RE: DRAINAGE PLAN FOR A.O.G. DISTRICT OFFICE (D13-D1G) ENGINEER'S STAMP
DATED 1/8/98

RE: CONCEPTUAL DRAINAGE PLAN FOR A.O.G. DISTRICT OFFICE (D13-D1G)
ENGINEER'S STAMP DATED 7/23/97

Sheet Title
CONCEPTUAL
Grading and Drainage Plan

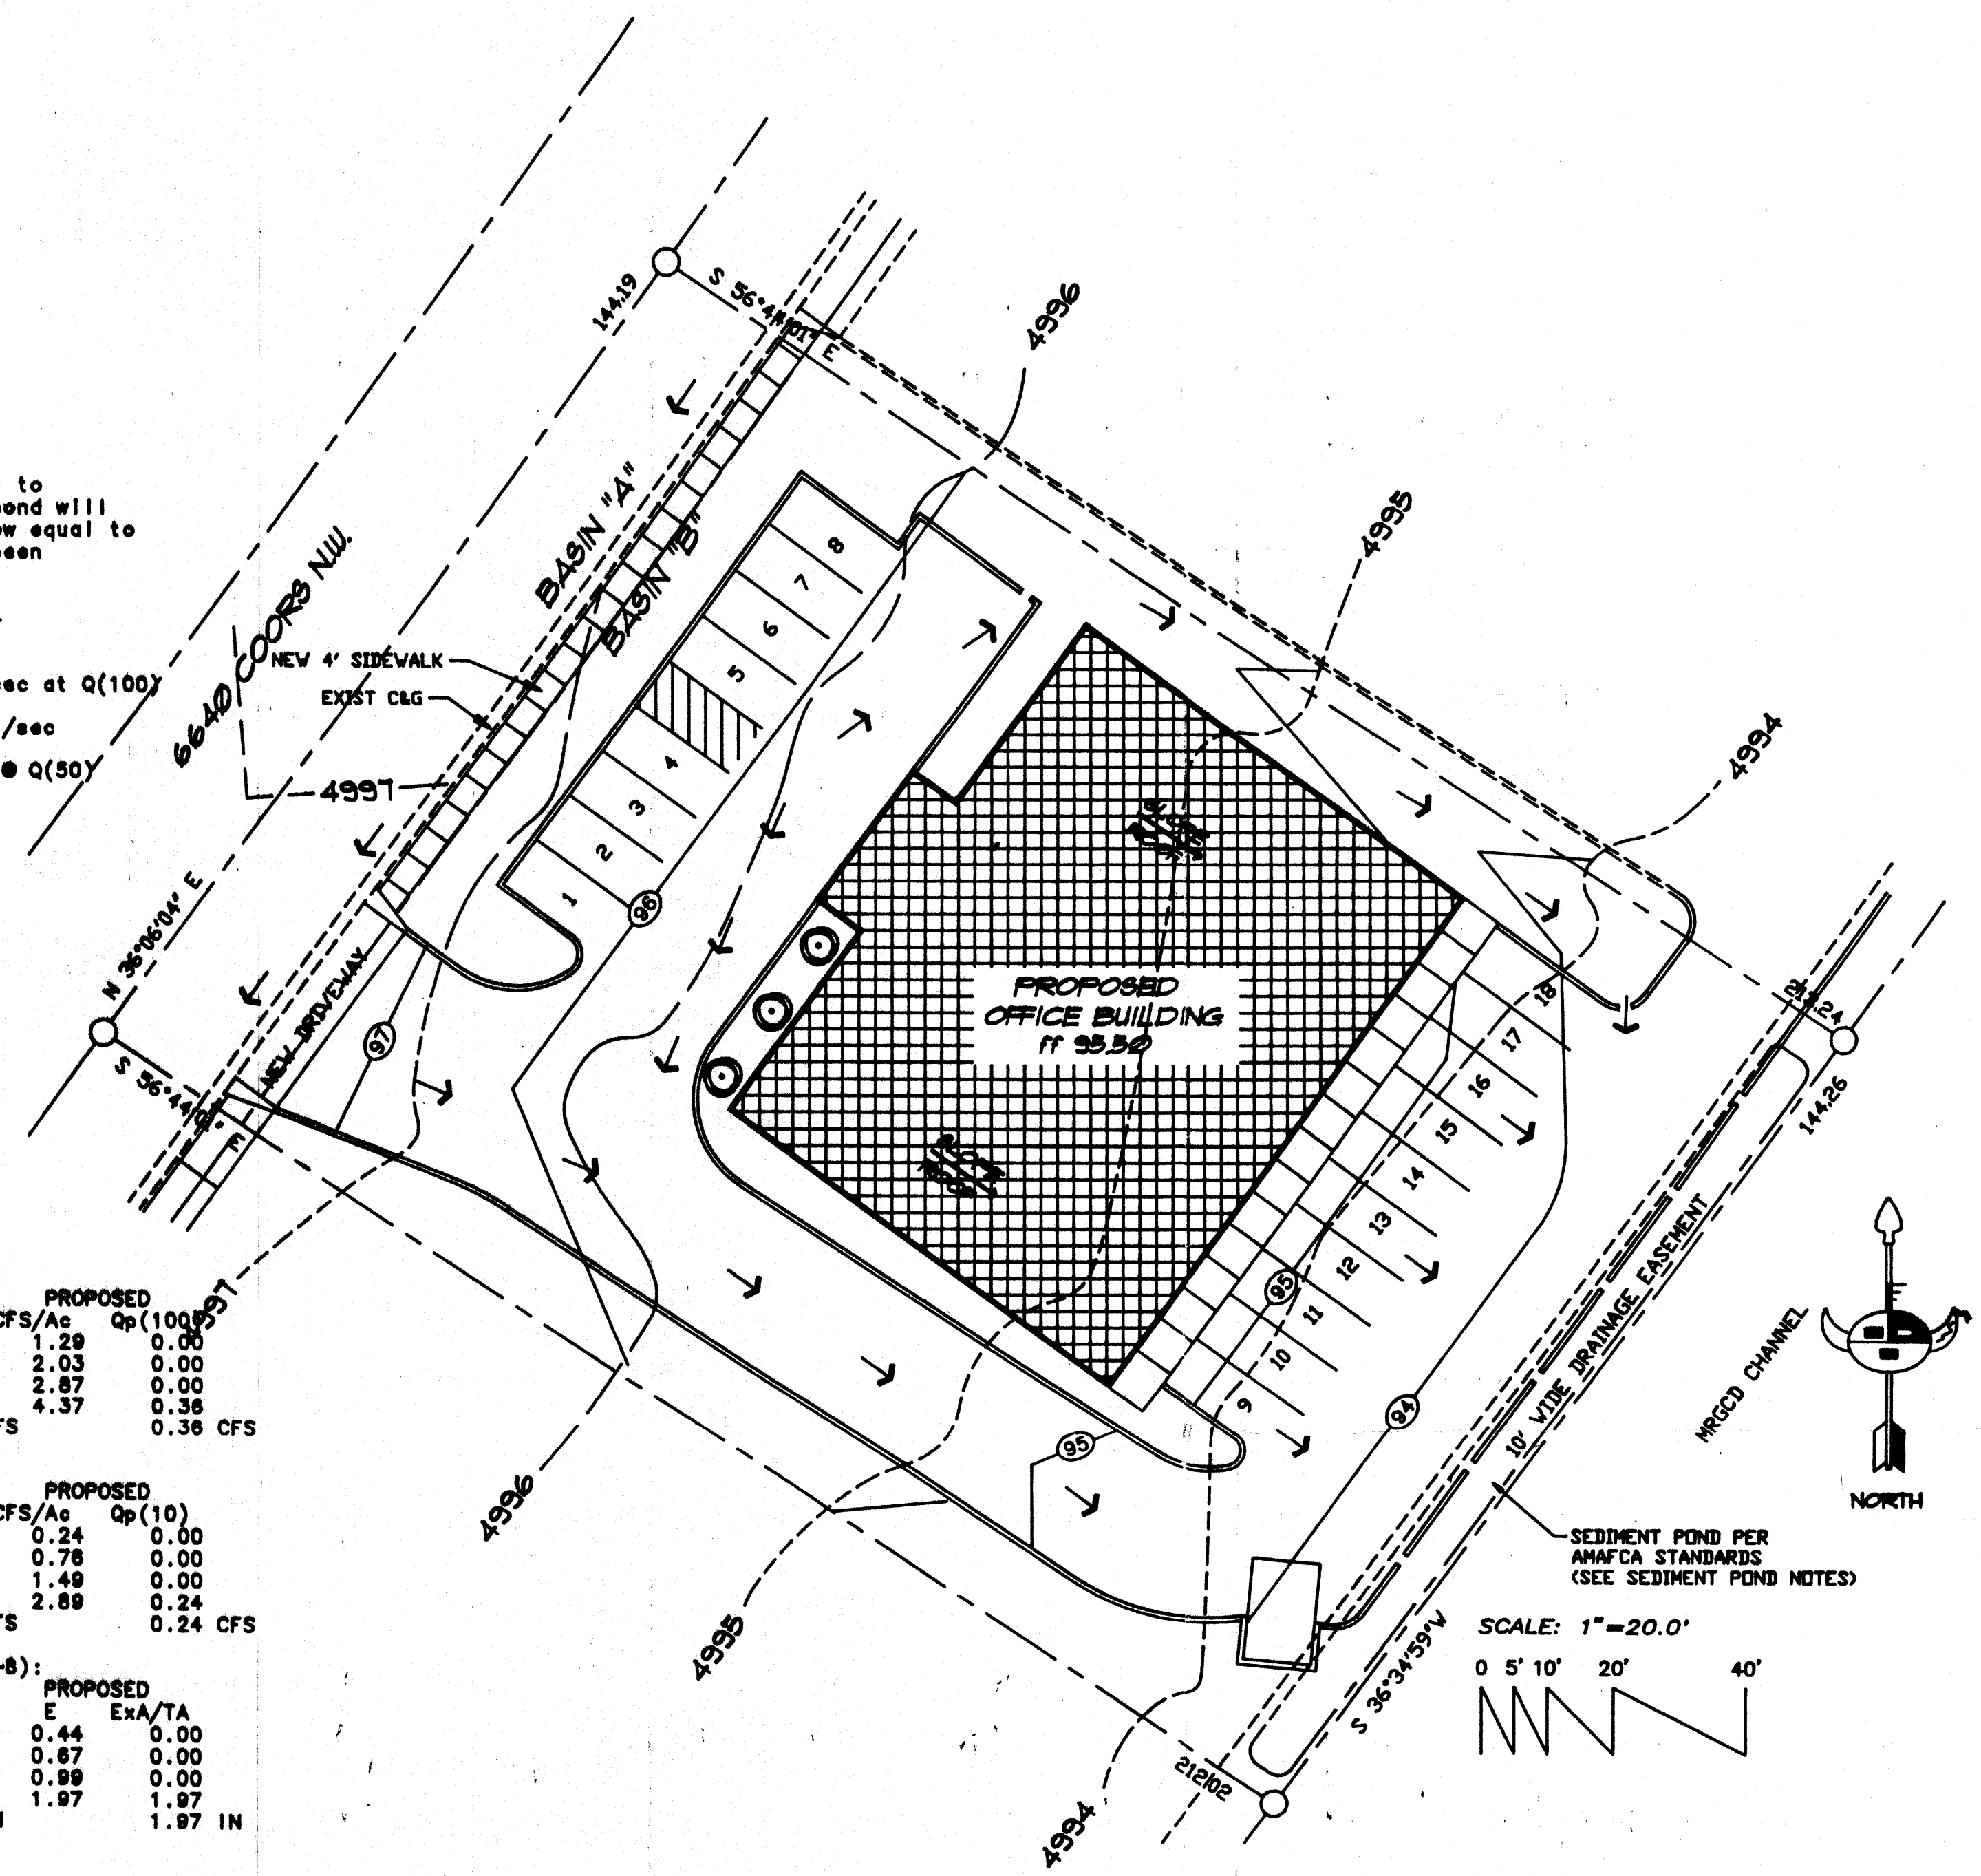
1. Sediment pond design and calculations.
2. Signature block for AMAFCA's approval.
3. Agreement and Covenant must have started the process.
4. Roof downspouts on the east portion of the building should be routed under the sidewalk.

Grading and Drainage Plan

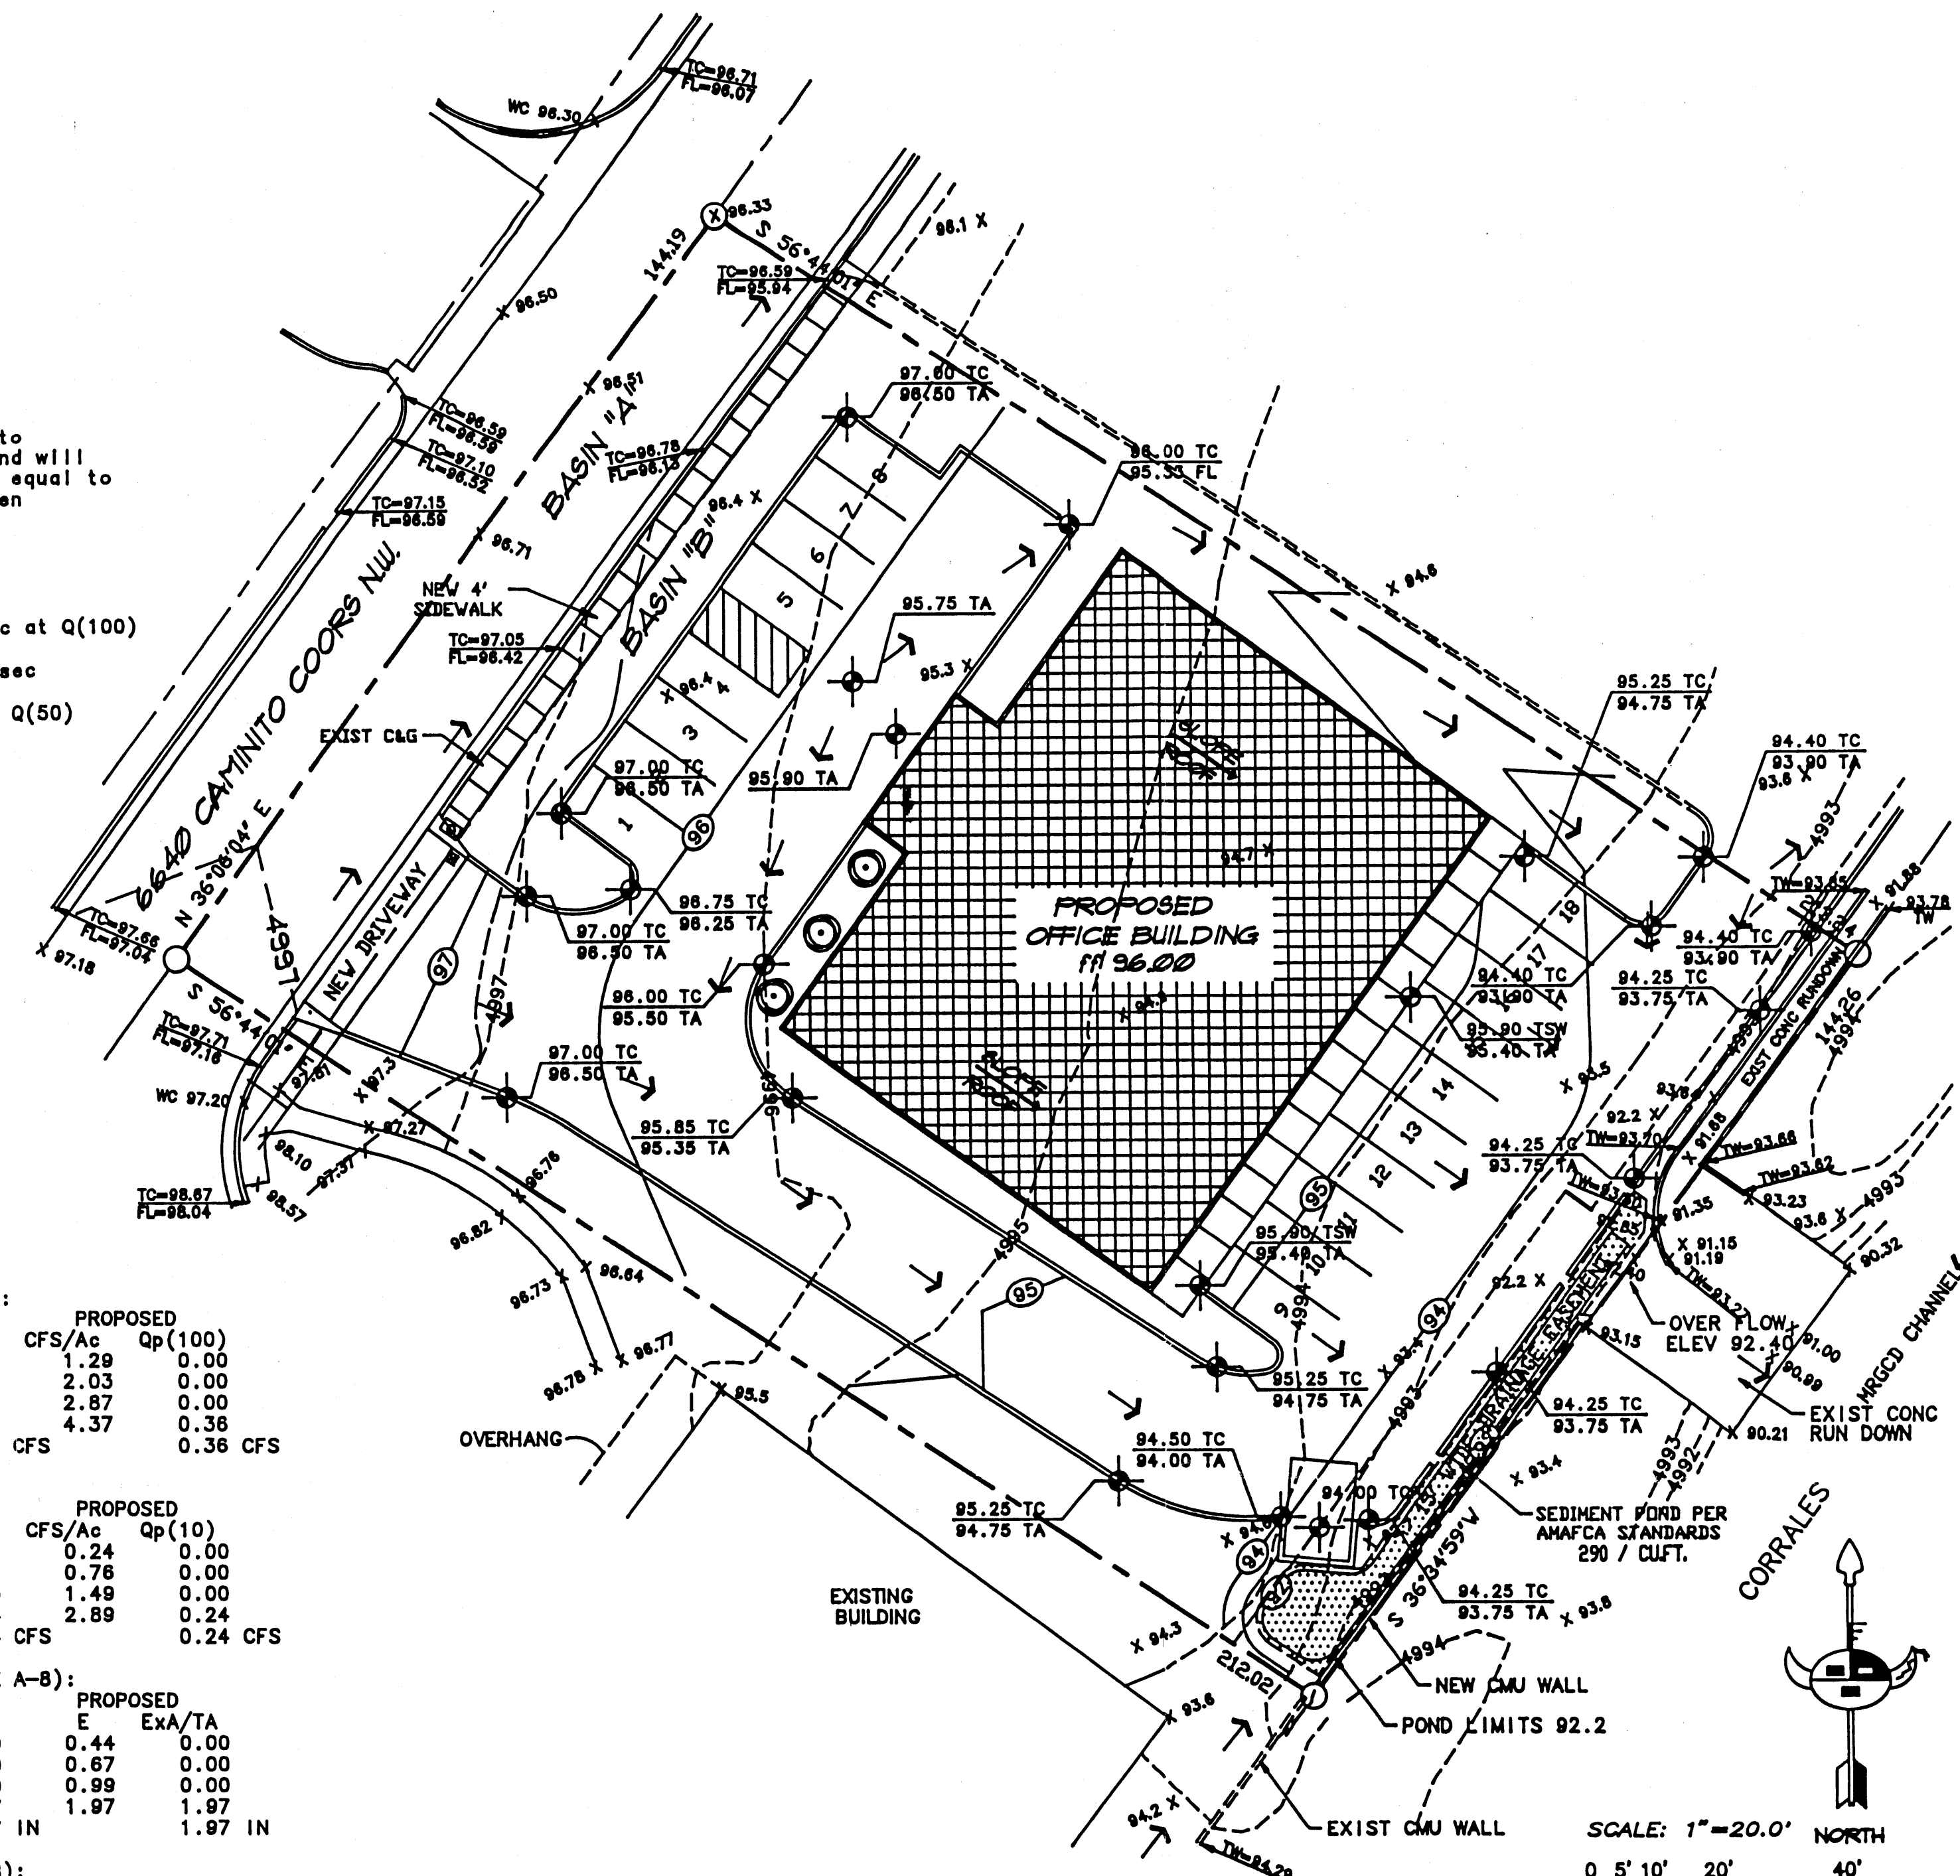
Based on the information provided on your January 8, 1998 submittal, the above referenced site is approved for Building Permit. Please attach a copy of this approved plan to the construction sets prior to sign-off by Hydrology.
